Pilar Aberasturi - Dept. of Planning referral for 157-163 Cleveland Street, Redfern

The City have completed a review of the Section 96, and can provide the following comments:

URBANEST REDFERN - S11341
SUBSTATION FACADE TO BE REINSTATED - EAST ELEVATION
SCALE: 1:50 @ A3
DATE: 27.11.12

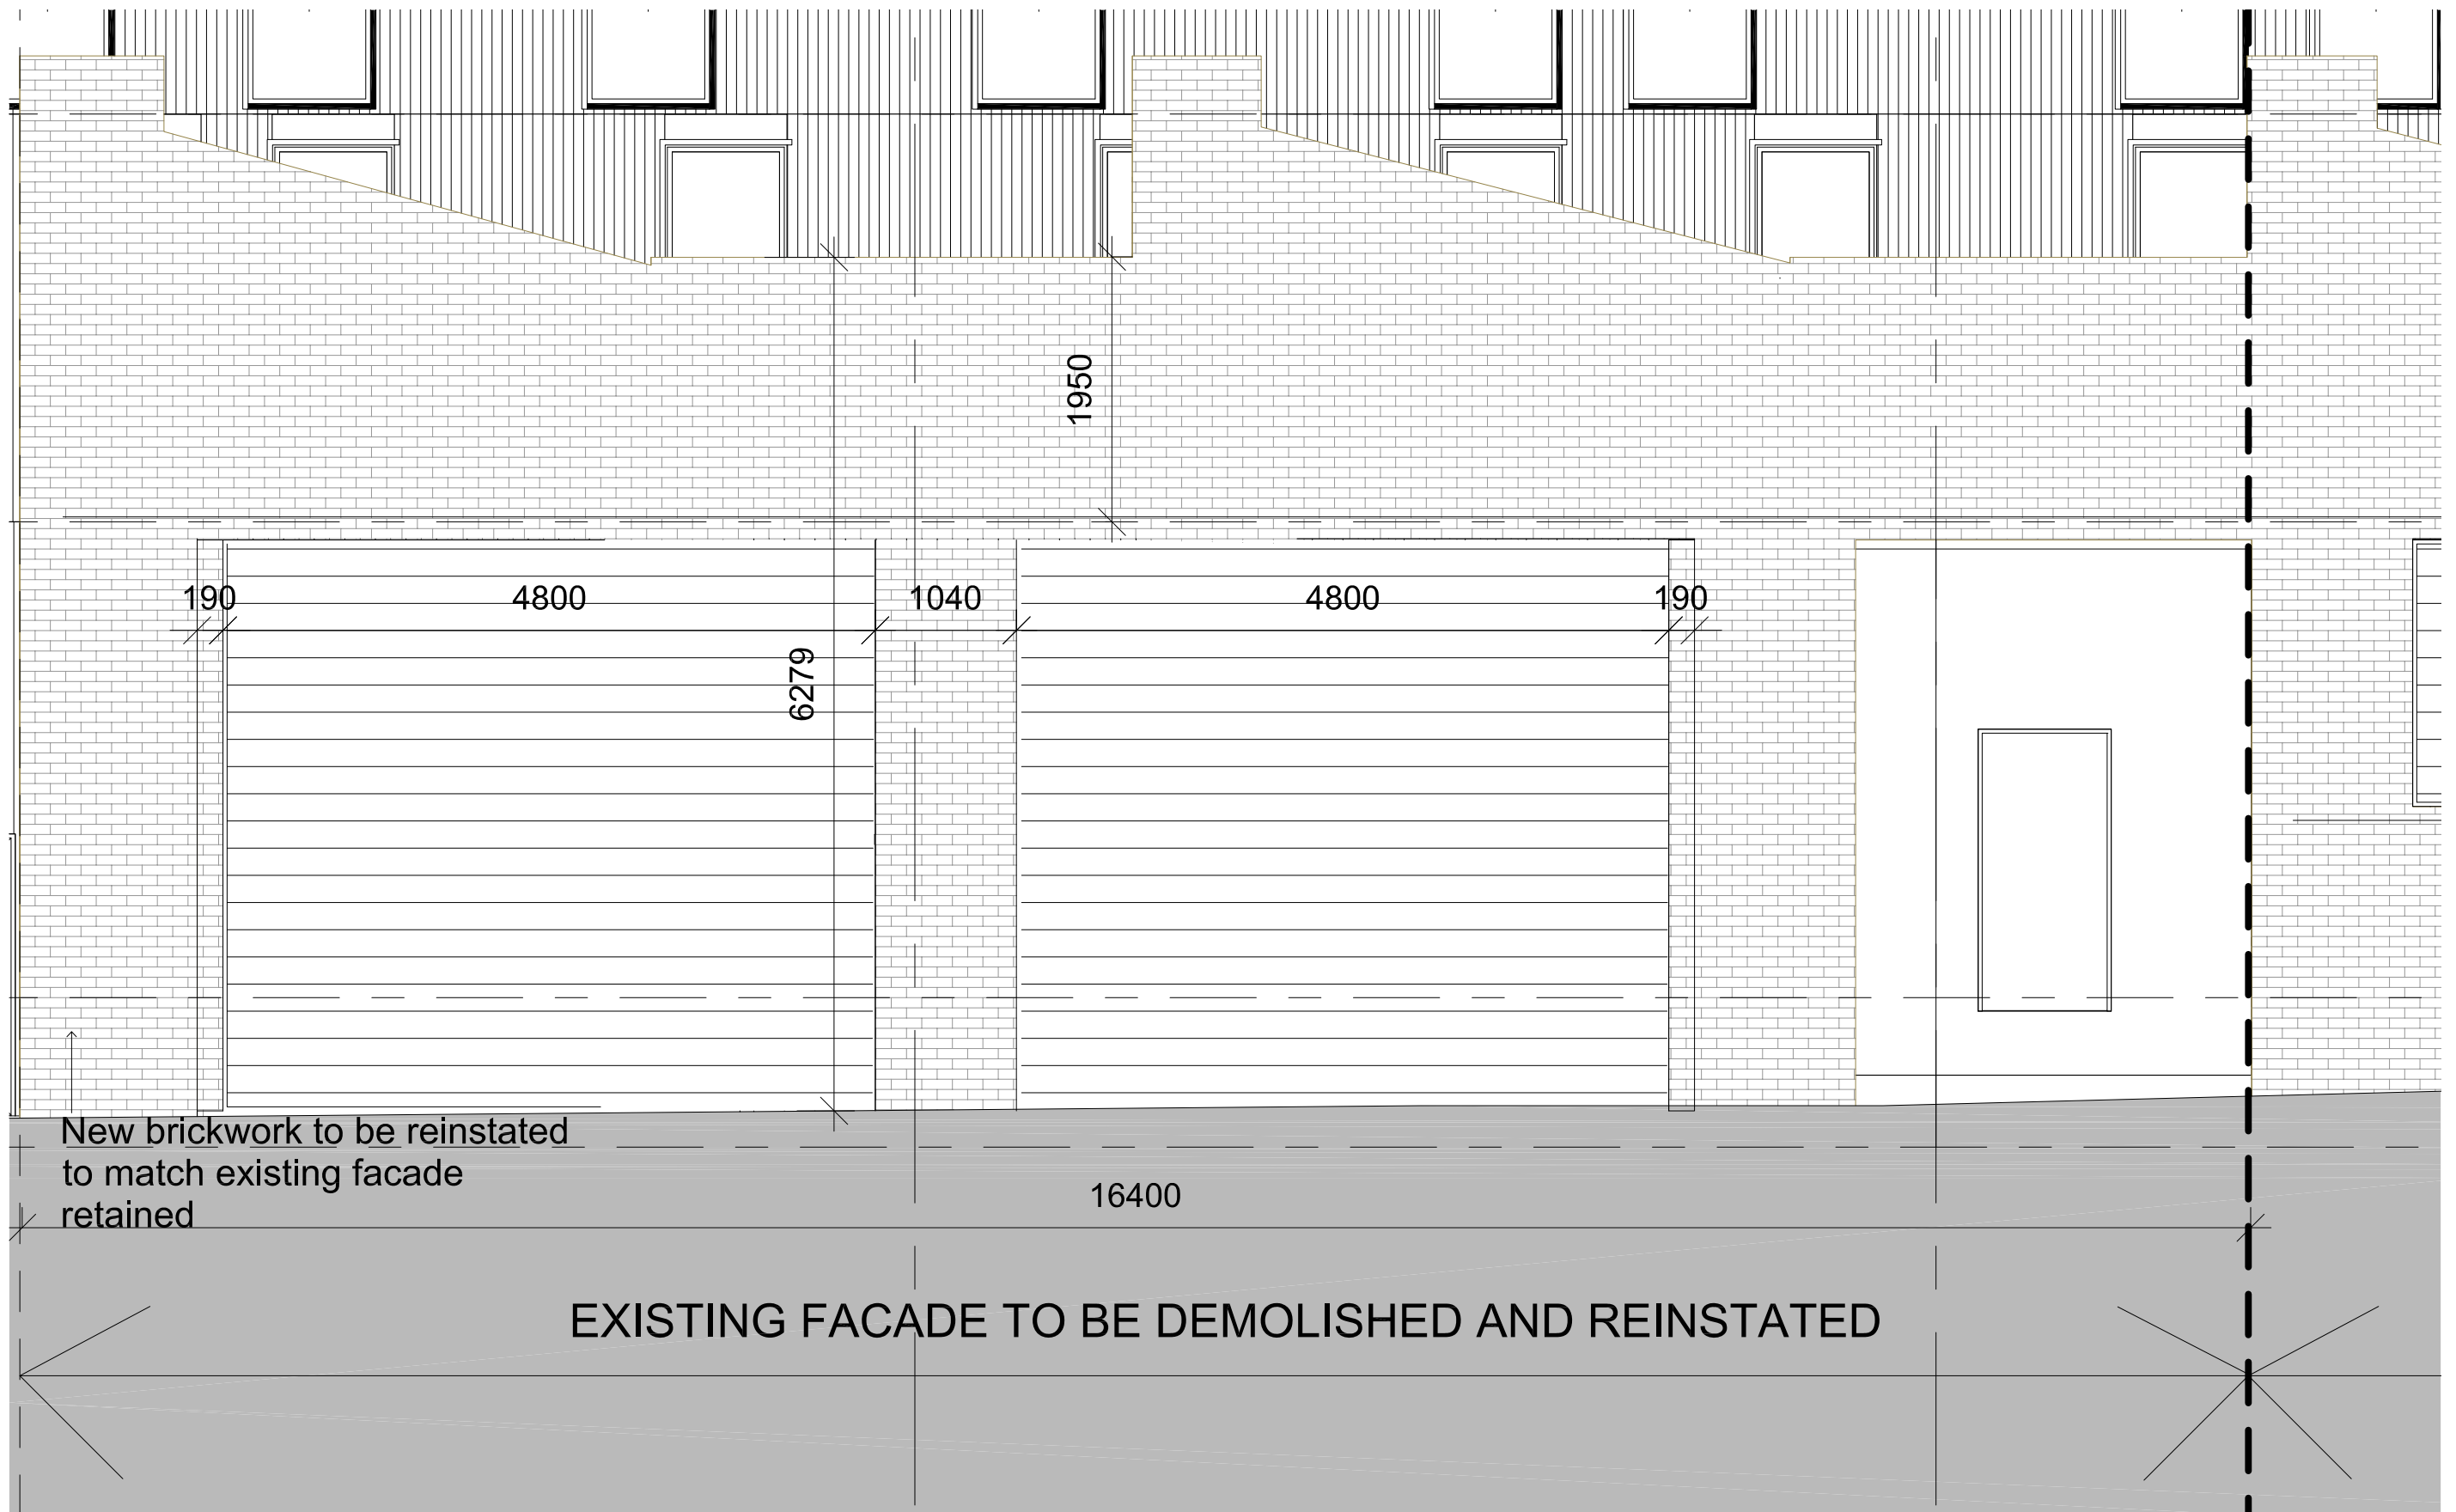
1. The proposed alternative archaeological strategy is **acceptable** and is probably better than the original strategy because it retains more of the archaeological resource on site in its original profile.
2. The proposed reconstruction of the section of the Hart Street warehouse wall is **acceptable** subject to the following conditions:
 - a. Bricks must be carefully salvaged during demolition, cleaned and re-used in the re-construction.
 - b. Re-construction is to be designed, documented and supervised by an appropriately qualified heritage architect. In particular, the brick set out, mortar composition and mortar detailing must match the adjacent retained fabric.
